AIR NAVIGATION, AIRSPACE AND AERODROMES BRANCH

CASA Ref: F23/1376-19

ST GEORGE PRIVATE HOSPITAL EXPANSION: CASA COMMENTS

The Department invited CASA to provide advice on the proposal. CASA has reviewed Aviation Impact Assessment Report 'Airspace Implications due to the Construction of the St George Private Hospital' Revision 1.1 by AviPro.

Figure 11: Elevation of the proposed development

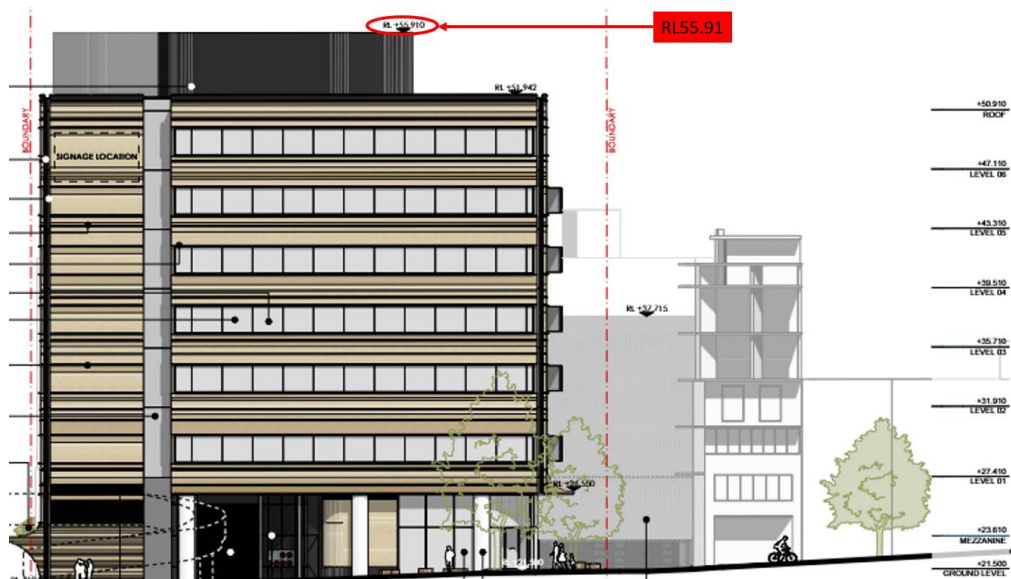
The Aviation Impact Assessment Report section 4.2 indicates the proposed building height of RL 55.91m. As advised at section 4.20, the Sydney Airport Inner Horizontal Surface is 51m and Approval will be required under the Airports (Protection of Airspace) Regulations. CASA is standing by to assess the building on receipt of an Invitation to Comment from Sydney Airport. As the infringement is small, the assessment will be a formality.
